# Submission on Bobs Farm Sand Mine Project SSD-6395 - Biodiversity

David C. Paull (MResSc)

29 January 2019

Figure 4.1– Proposed Sand Mine with Aerial (Tattersall Lander, 2020)

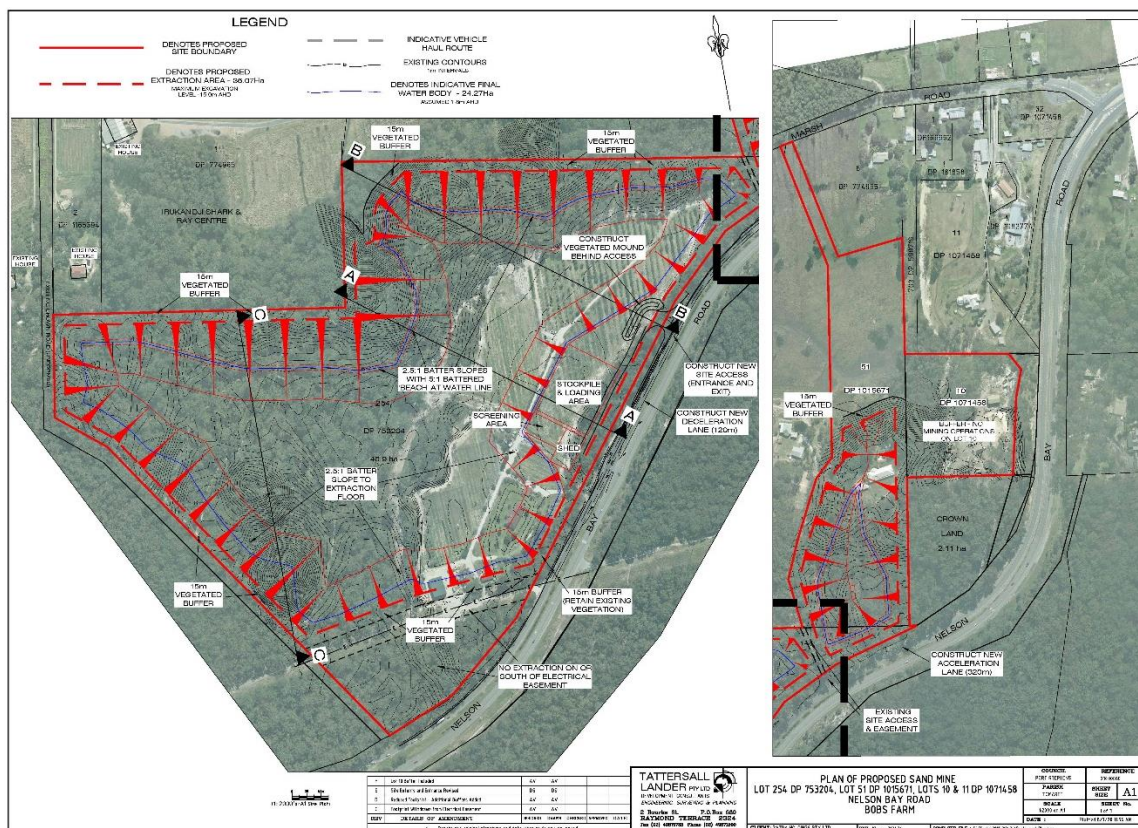
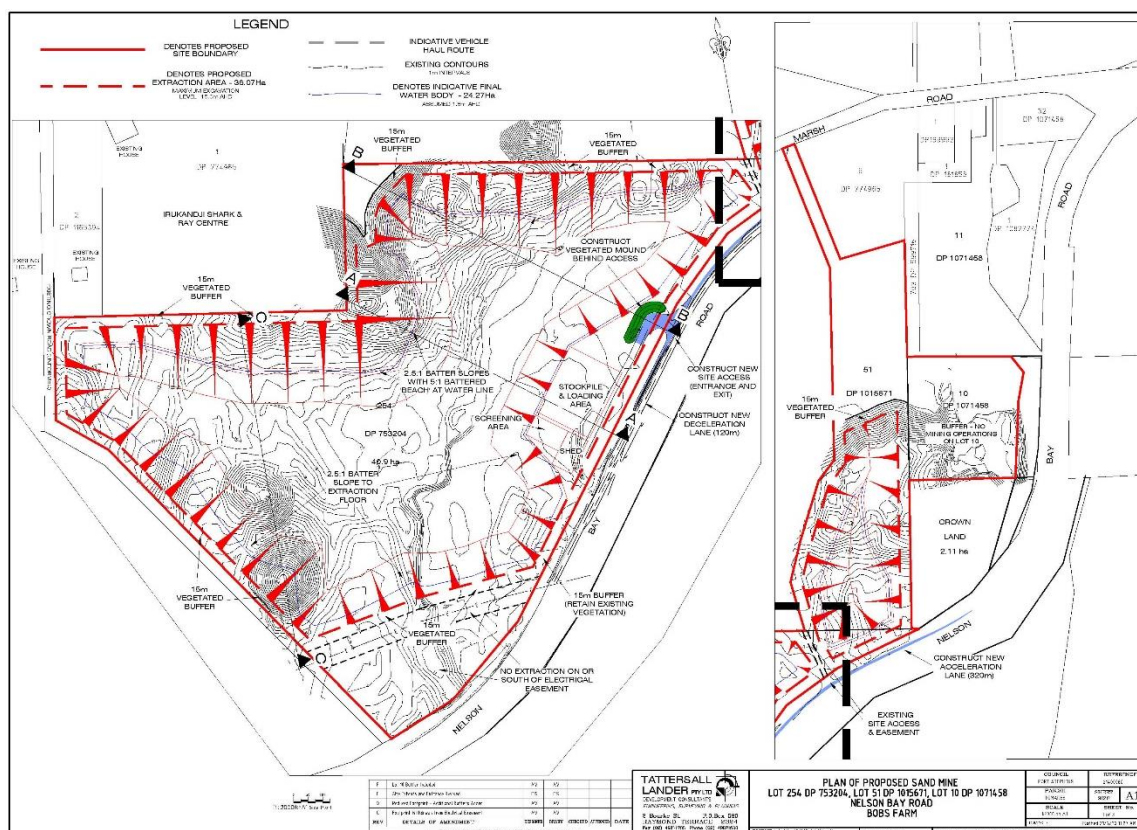
- There has been a poor assessment of impact on habitat connectivity by the consultants and no acknowledgement that the project will result in the effective loss of connectivity width by 99%. A 15m wide roadside buffer may not be sufficient to allow the movement of sensitive species, such as the koala, through the locality.

The proponent claims that the section of the corridor where the study area is located is approximately 1.5km wide and that the proposal will result in the reduction in the width of the corridor on the western side of the dual carriage way of Nelson Bay Road by approximately 540m at its widest point. However, this width counts sections on both sides of the Nelson Bay Road dual carriageway which is itself a significant barrier to fauna

If the loss of connectivity of the proposal is looked at objectively, and taking into consideration the highway barrier, the proposal will remove an important piece of local and regional connectivity by approximately 99%. A 15 m wide buffer along the road cannot be considered to optimal conditions for a wildlife corridor. This level of impact is highly significant at both regional perspective for the connectivity of habitat for fauna dispersal and the maintenance of genetic diversity in populations.
